A428 Black Cat to Caxton Gibbet improvements

TR010044

9.119 Applicant's comments on submissions received at
Deadline 9

February 2022

Drawing Number
HE551495 -ACM -ELS -
GEN_SW_Z_ZZ_DR-LV-0015
Location I Type I Role I Number

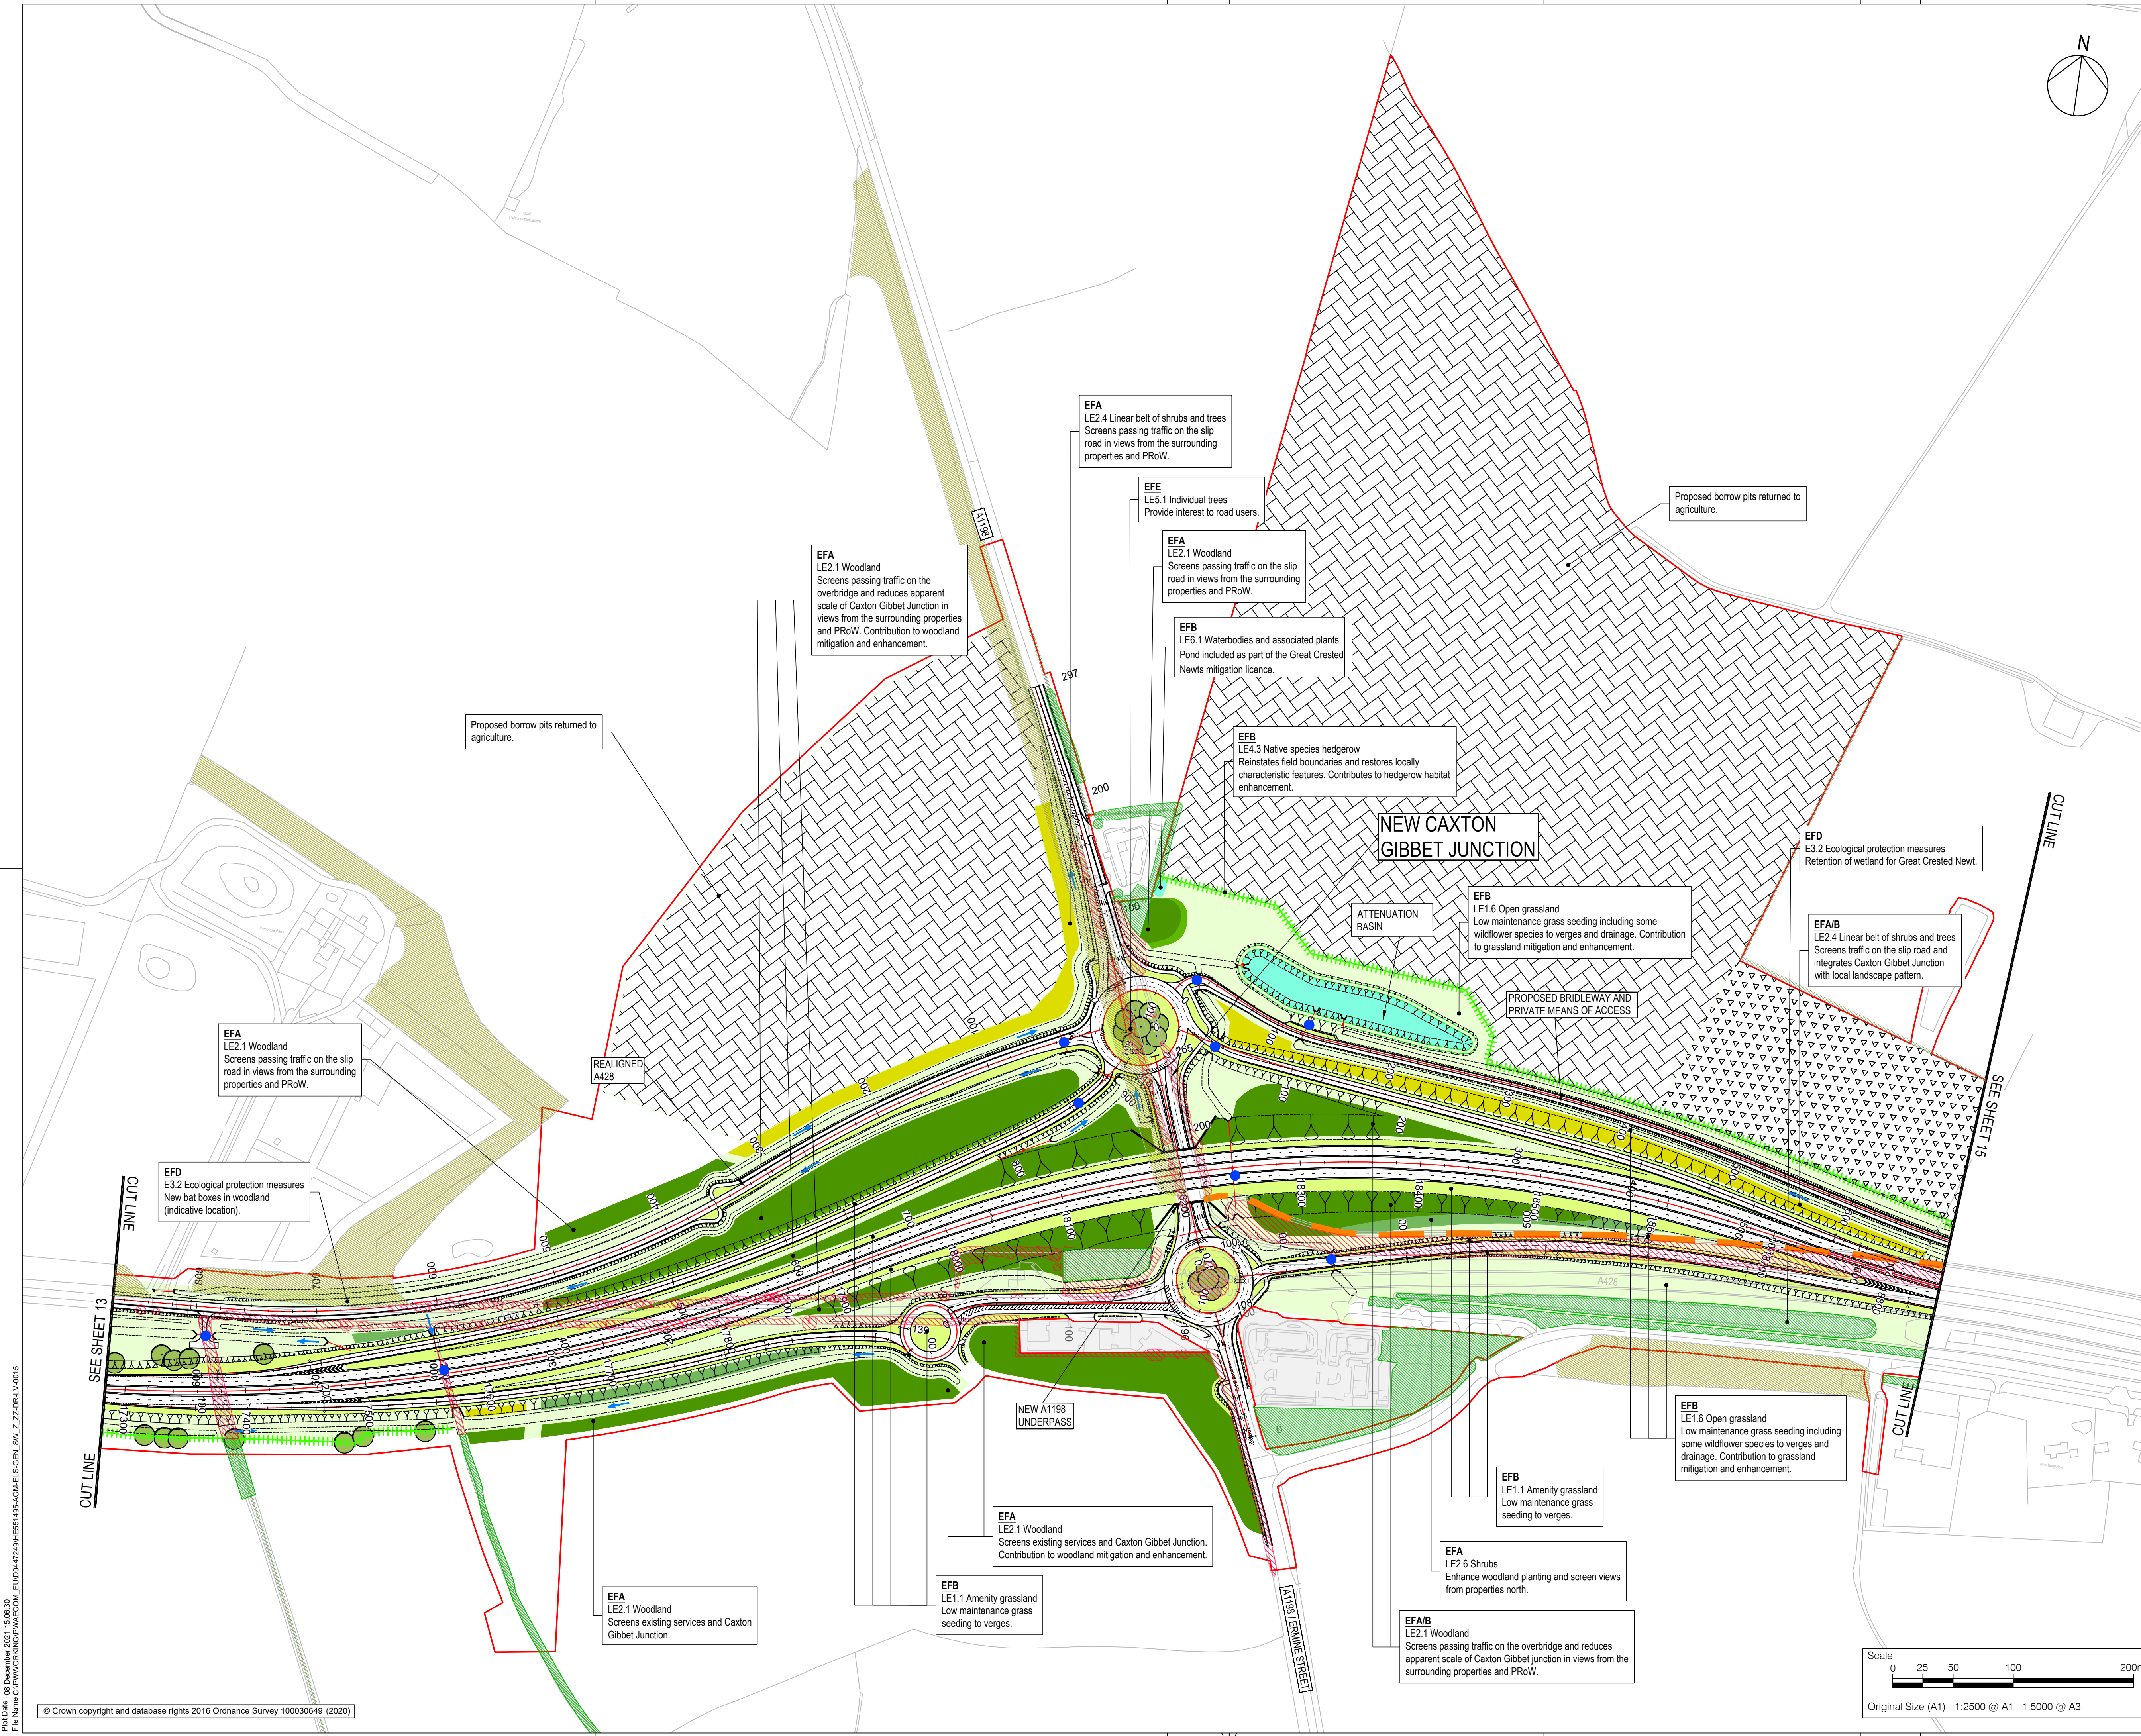
REP9-044d	<p>Aquatic Environment and Biodiversity - 3.3.6.1</p> <p>b) The Councils welcome clarification of the proposed enhancement works to pond 83, which mitigate the loss of two other ponds within Cambridgeshire (ponds 37 and 84).</p> <p>The Councils seek an update to the First Iteration Environmental Management Plan [REP6-008] and Environmental Masterplan [REP6-006] to include these proposed enhancement works and management.</p>
Applicant's comments	<p>The Applicant notes the response provided by the Cambridgeshire Authorities.</p> <p>Annex D of the First Iteration Environmental Management Plan submitted at Deadline 9 [REP9-009] includes restoration of retained Pond 83, as stated in Section 1.11 and Annex L was updated in Sections 1.11 and 1.15 to include restoration and long-term management of retained and created ponds. The pond location near the Caxton Gibbet junction is shown on the Environmental Masterplan [REP9-037] on DR-LV-0015.</p>
